Planning Services Sign Permit Review Form

Date of Submittal	Application Number	Applicant	Landowner
2/28/2023 Resubmitted 6/30/2023	SIGN2302-0001	Blashfield Sign Company, Inc.	Wellco Contractors Inc. NCDOT

Contact Person	Jan Wright	Contact Number	910-485-7200
Sign Location	NCDOT ROW Magnolia Drive & Nursery Rd.	PIN Number	0526-50-6140.000

Site Plan – Sign in NCDOT ROW

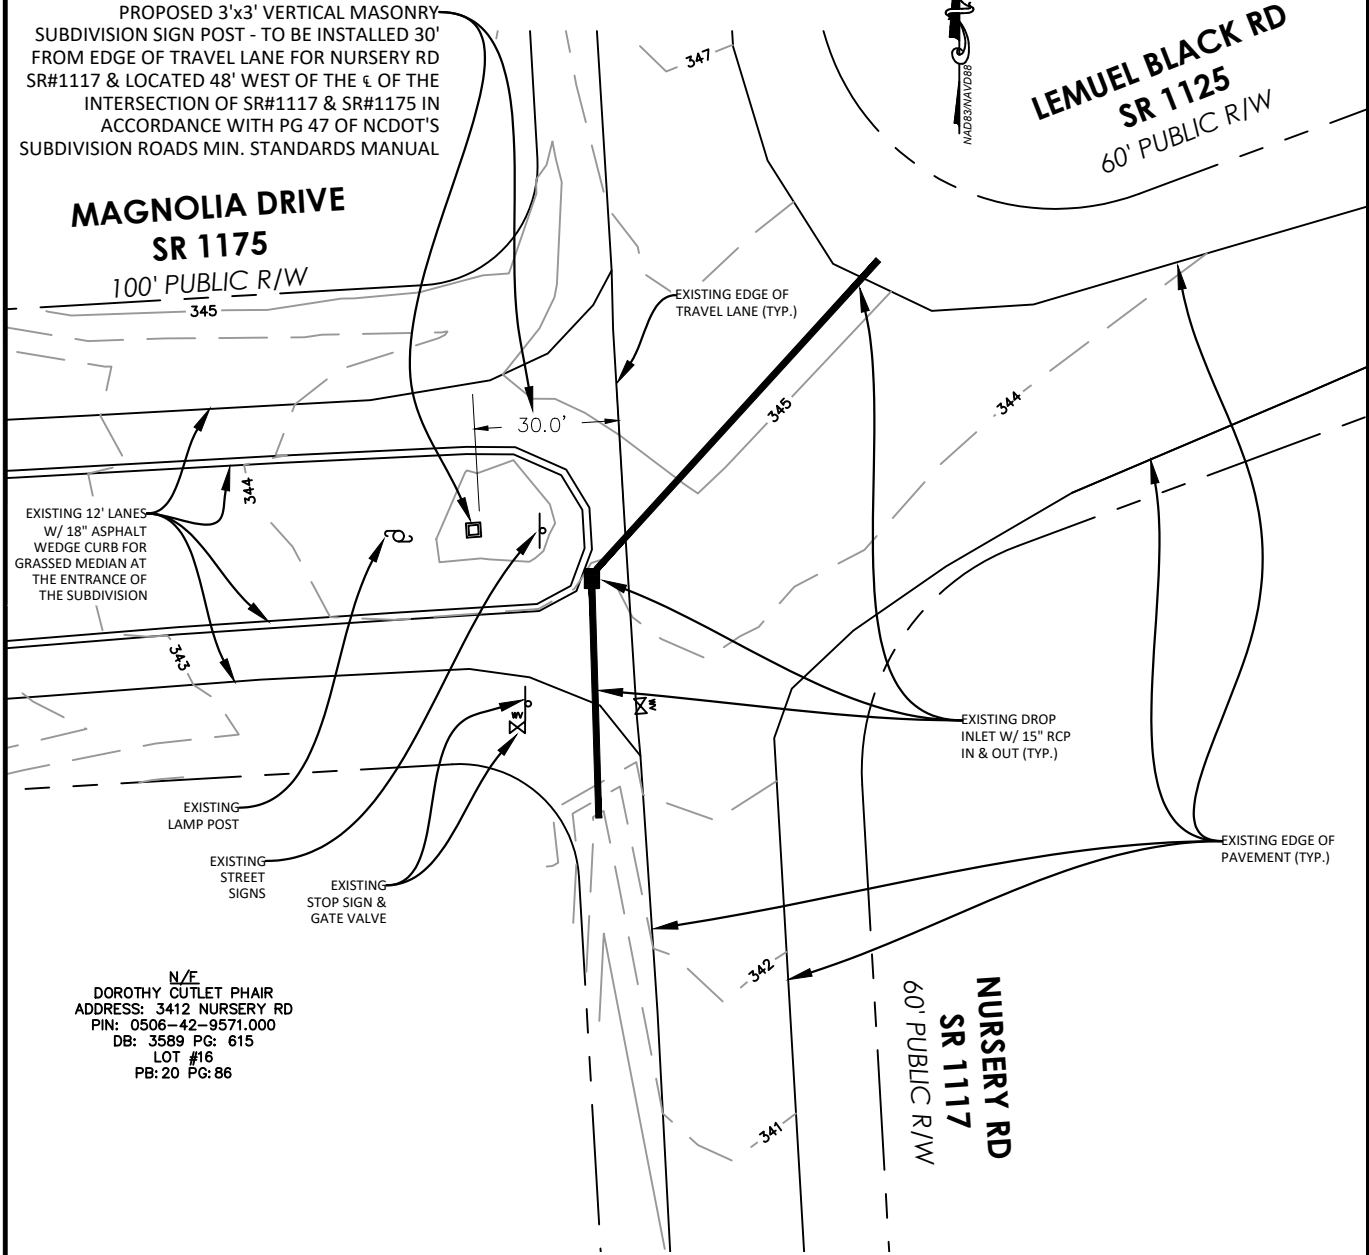
Comments	<p>1. Applicant has secured ROW encroachment agreement from NCDOT. The sign must be located 30' back from the nose of the island approximately 40' from the edge line of SR 1117.</p> <p>2. Sign meets the dimensional requirements of the UDO.</p>
----------	---
